# **A46 Newark Bypass**

**Scheme Number: TR010065**

## **Statement of Common Ground with Newark and Sherwood District Council 'NSDC'**

**February 2025**

Drawing file: TR010065 / TR010065-000155-TR010065_A46 Newark Bypass_6.2 Figure 2.3 Environmental Masterplan.pdf

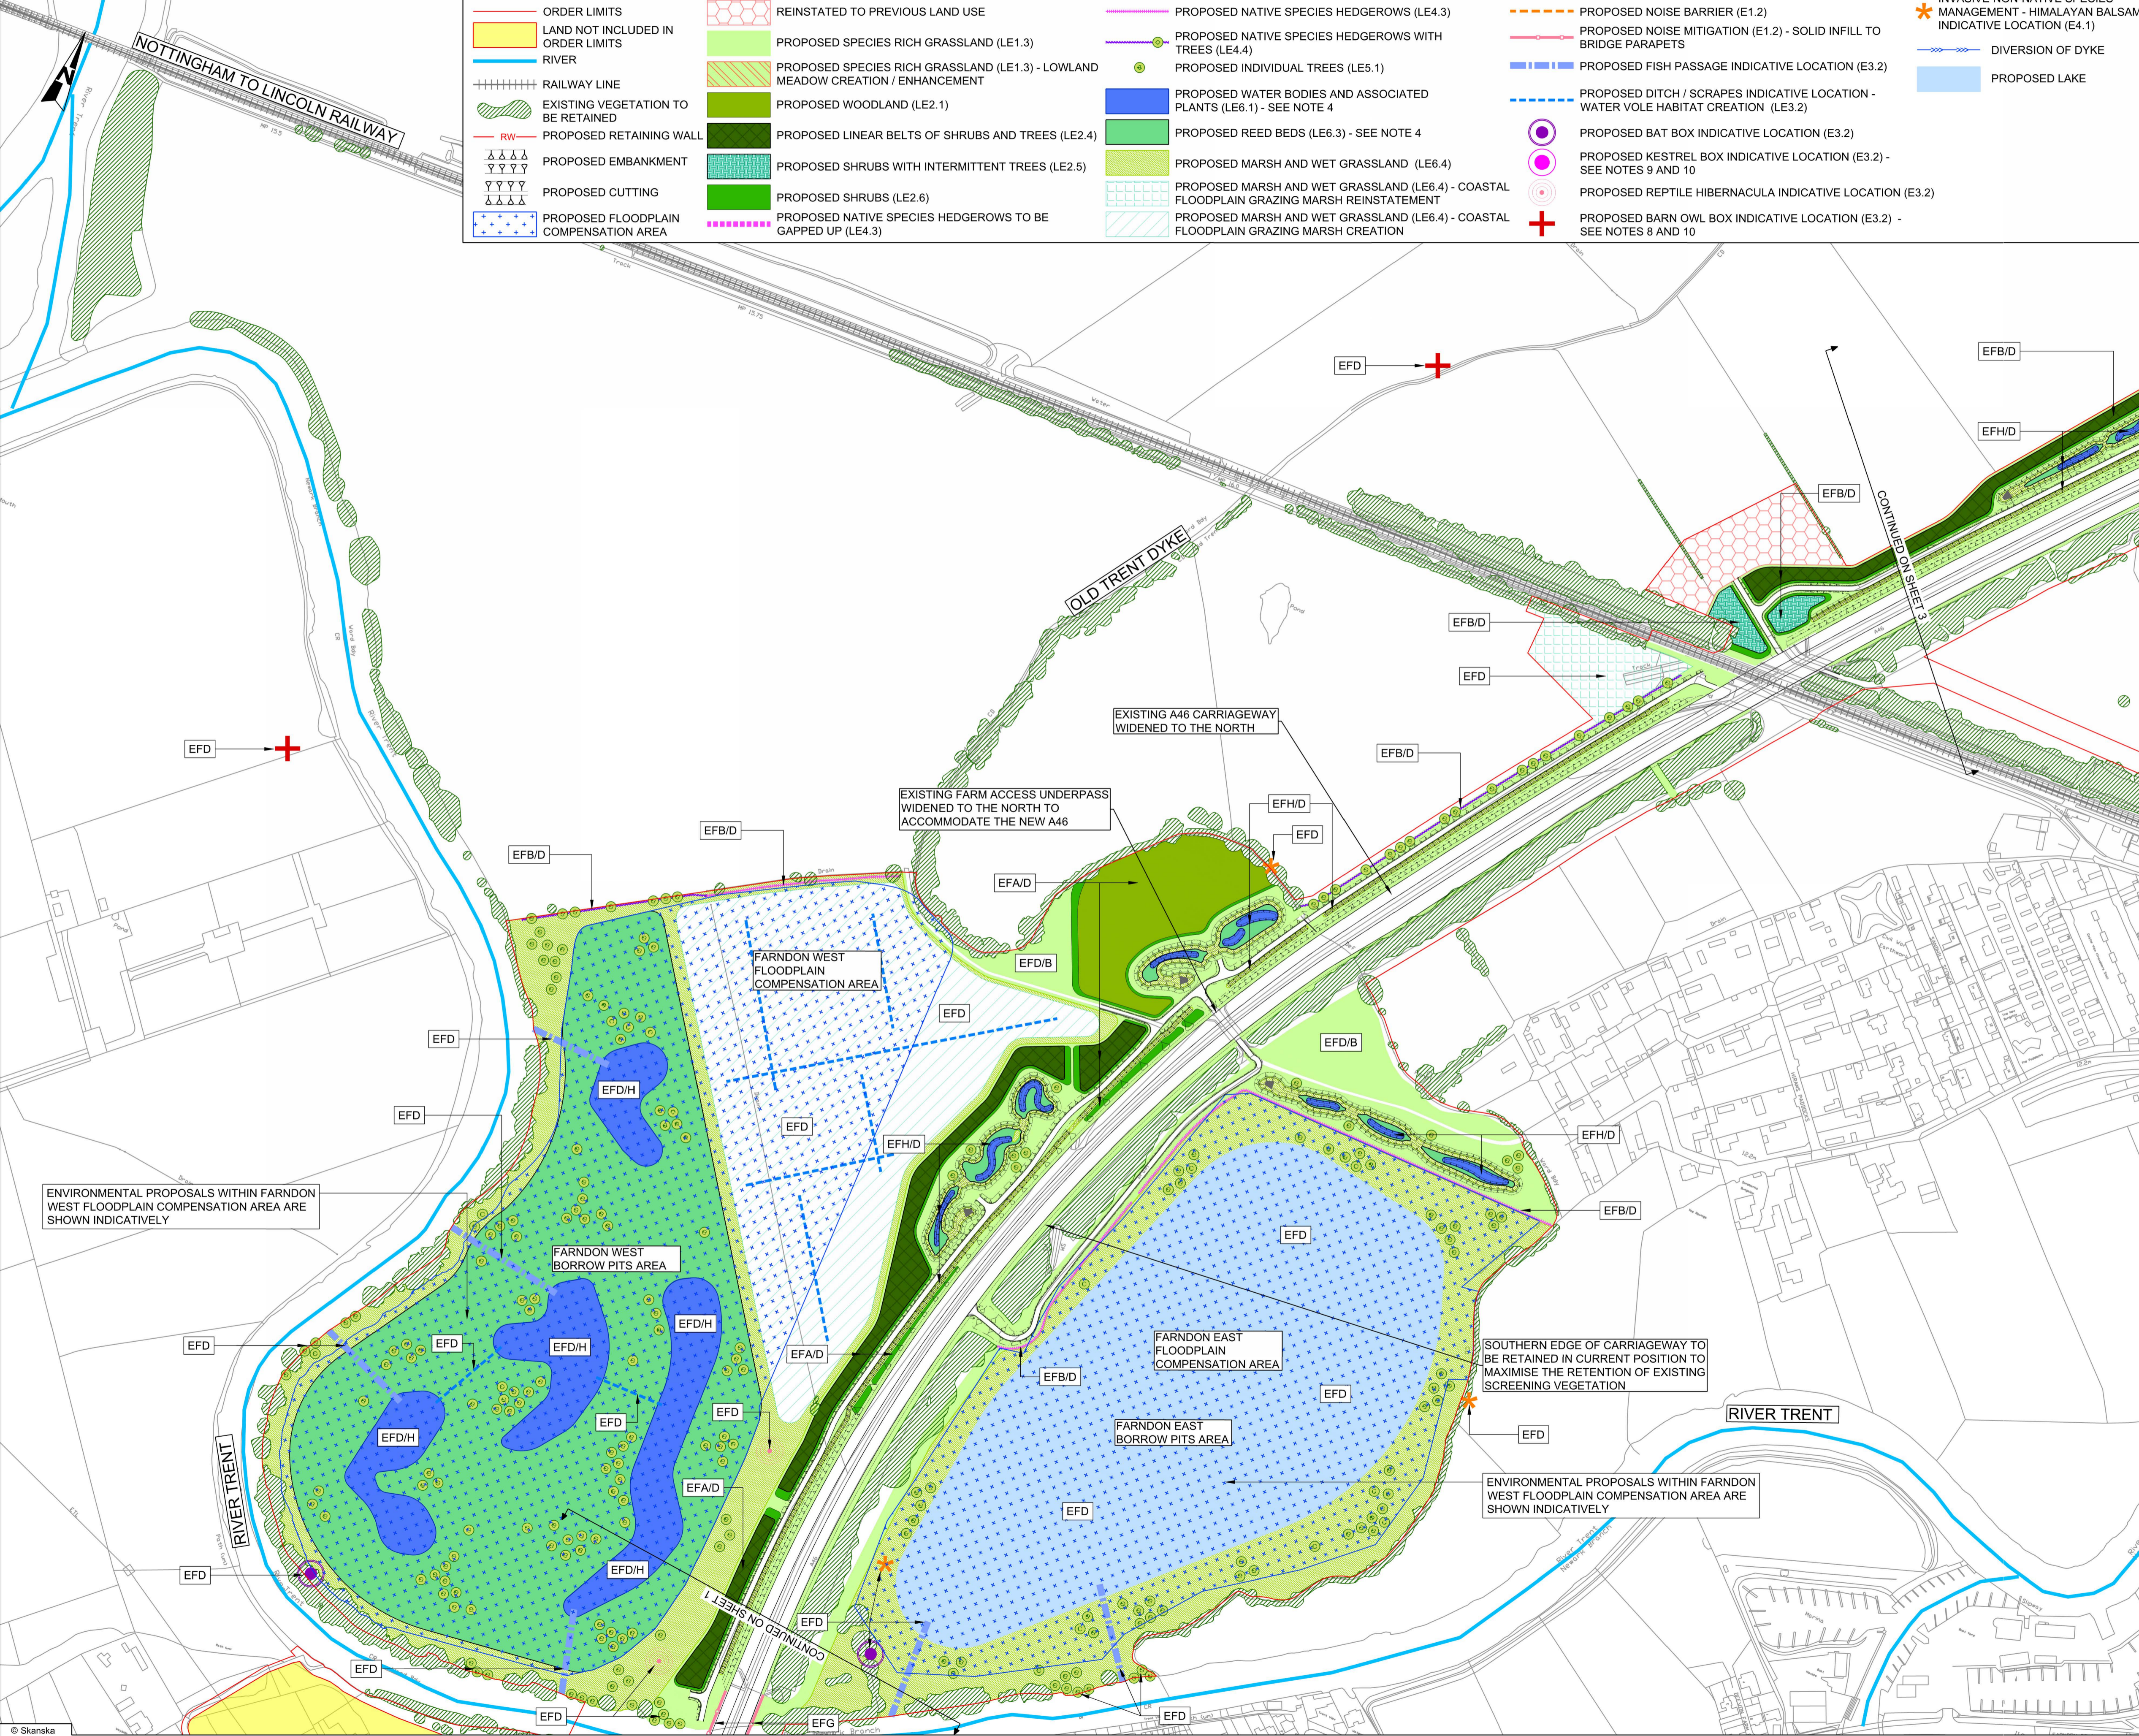
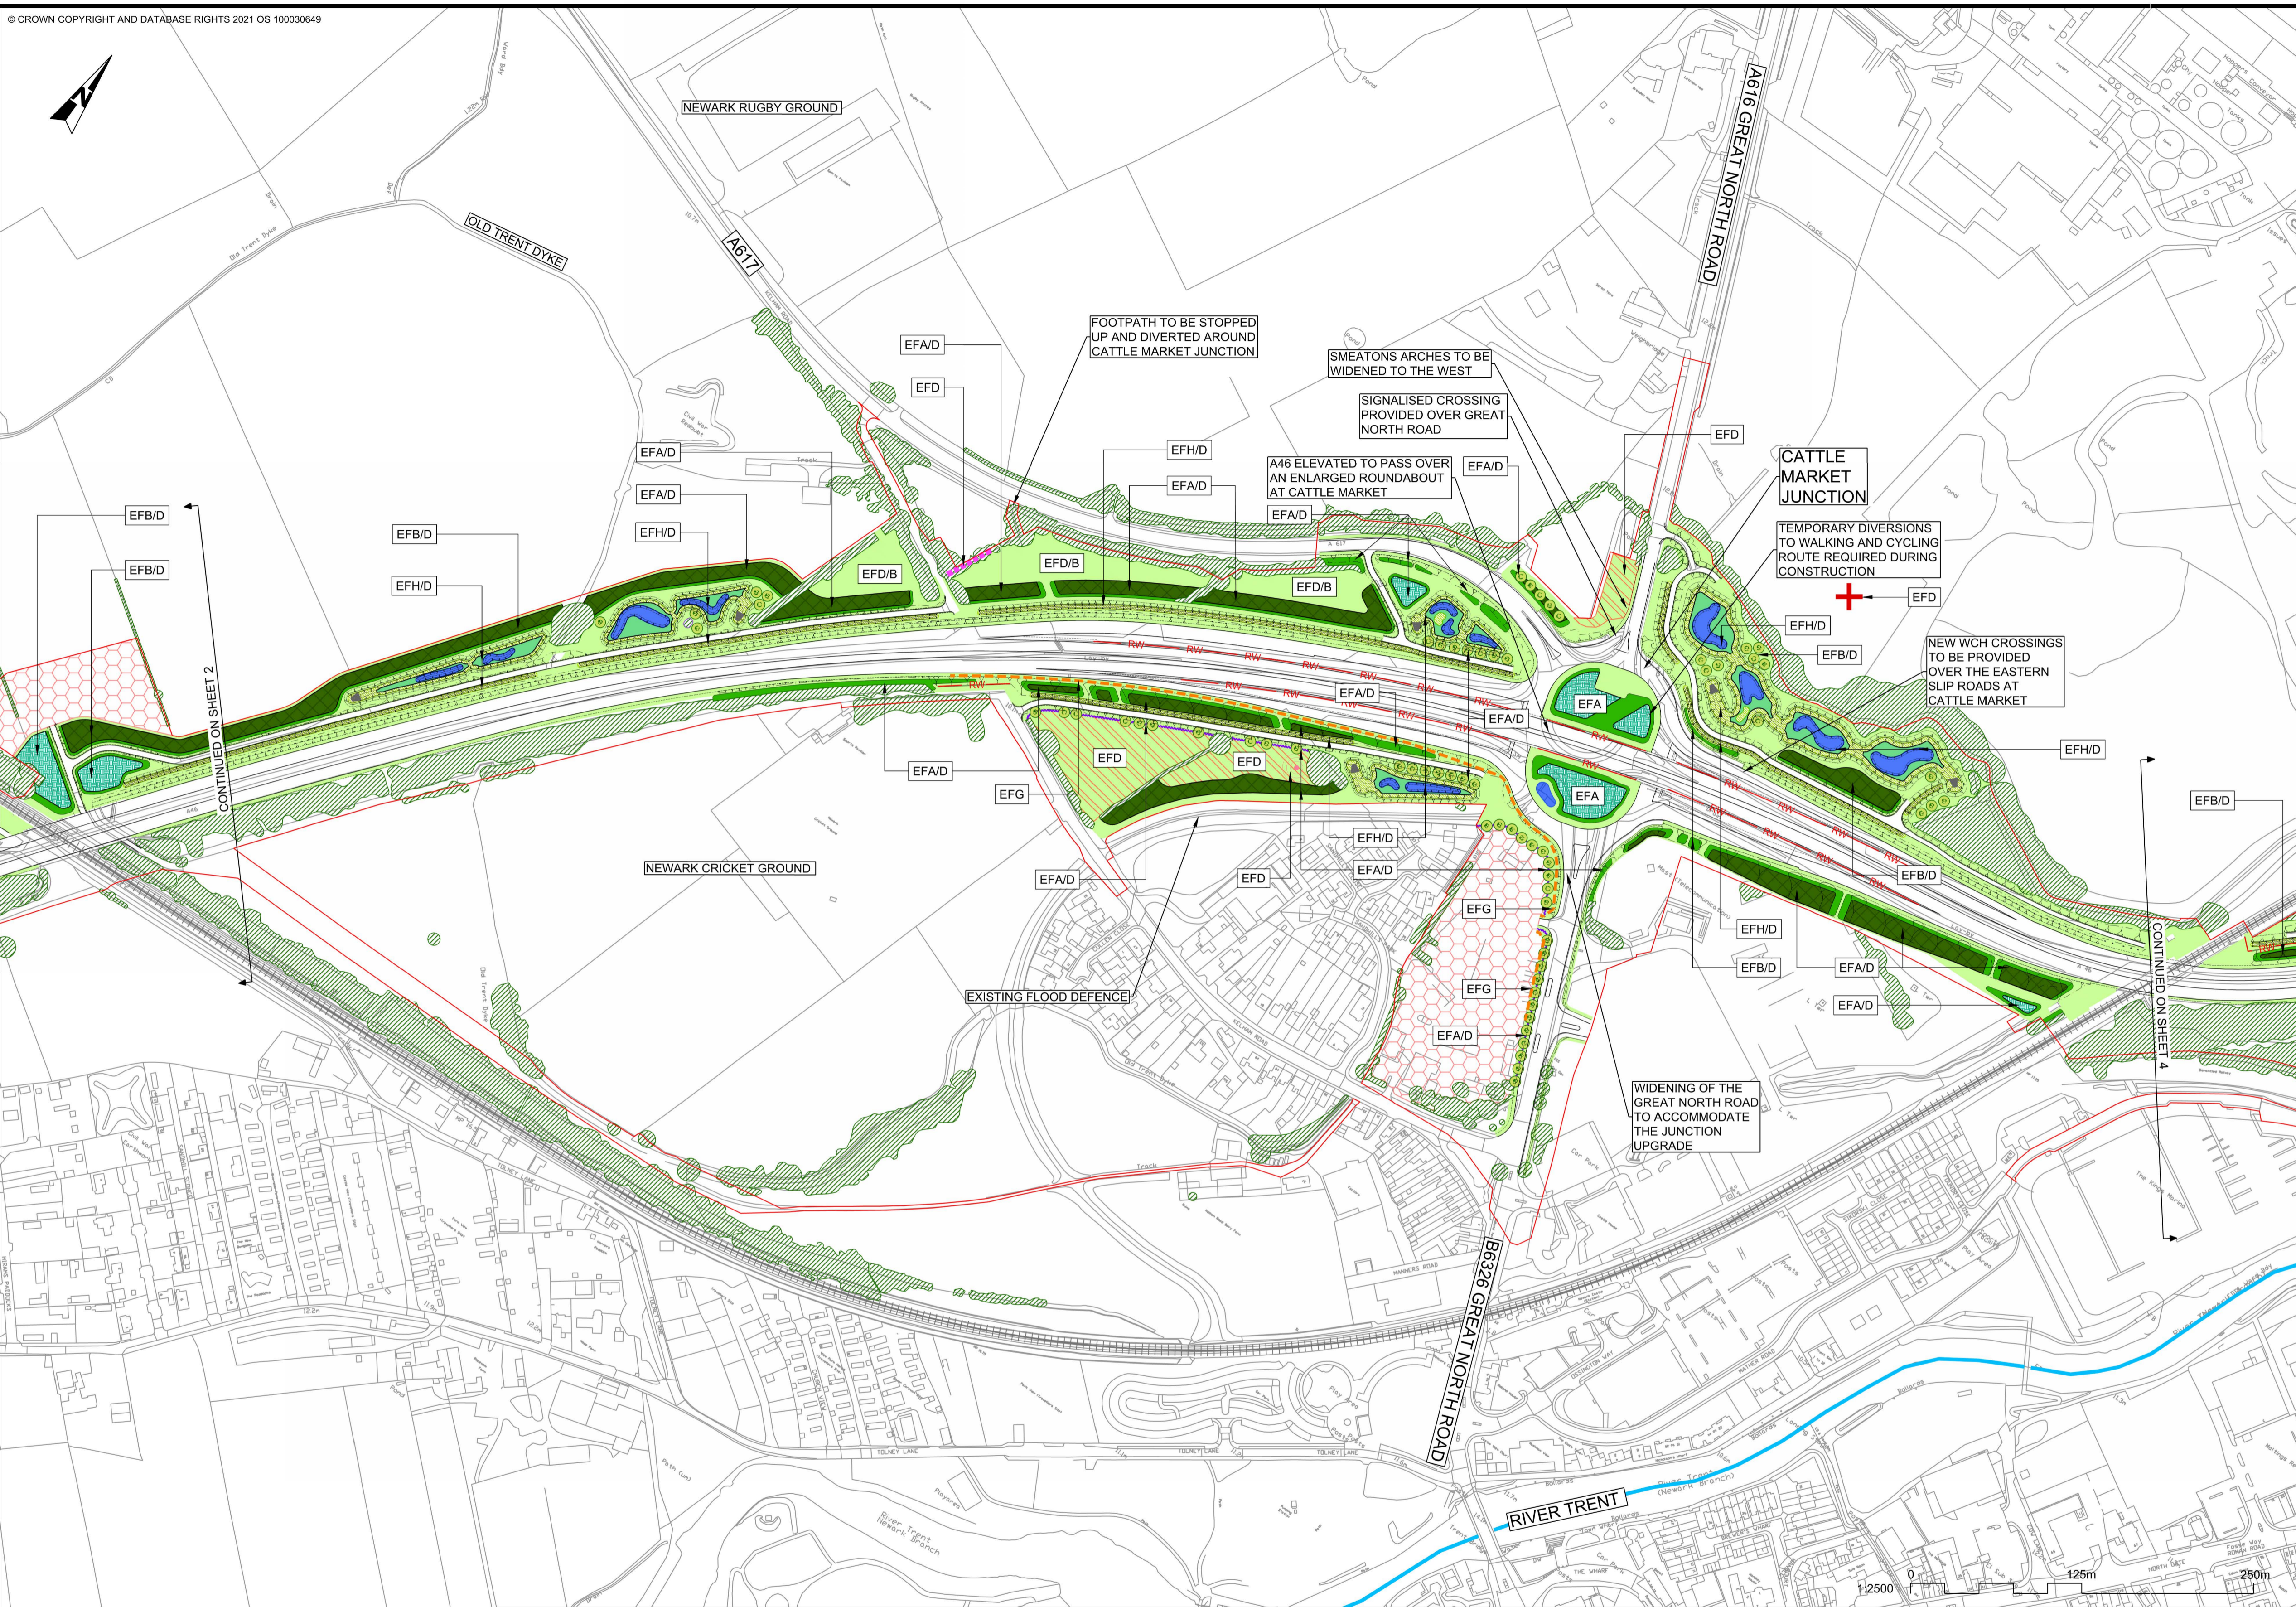
12.	Design (including justification for any flexibility being sought)	Chapter 2 The Scheme of the Environmental Statement [APP-046]  6.2 Environmental Statement - Figure 2.3 Environmental Masterplan [AS-026]	<b>Cattle Market flyover</b>  On the fly-through video the structure of the elevated over-pass at the Cattle Market junction appears as a stark and imposing concrete structure. This may be in part due to the animation which depicts it as being very bright in colour and therefore standing out vividly. The Council would want to understand proposals to ensure the visible impact of the final structure is minimised and/or mitigated as far as practicable.  03/02/2025 – Although this structure is now understood we still continue to raise concern with the impact the structure would have on the surrounding area.	Consideration has been given to the aesthetic finish of the structure during the design development to help to reduce the visual prominence of the structure and to reflect finishes on existing structures such as that of Smeaton's Arches just to the north of the new junction. Further details of these can be found within Chapter 2 The Scheme of the Environmental Statement [APP-046] and 6.2 Environmental Statement - Figure 2.3 Environmental Masterplan [AS-026].  Planting of trees and shrubs has also been considered and incorporated wherever feasible to help break up the visual mass of the structure, with planting softening the built form and aiding screening over time, particularly from properties such as those in Sandhills Park affording near distance views.  The assessment of landscape and visual effects and associated design and mitigation measures are described in 6.2 Environmental Statement - Figure 2.3 Environmental Masterplan [AS-026] and presented in 6.2 Environmental Statement - Figure 2.3 Environmental Masterplan [APP-026].  Part of the Detailed Design process will be to define the finish of the retaining walls forming the Cattle Market Flyover. This will be a masonry type façade and not a bare concrete finish.	Not Agreed	20/02/2025
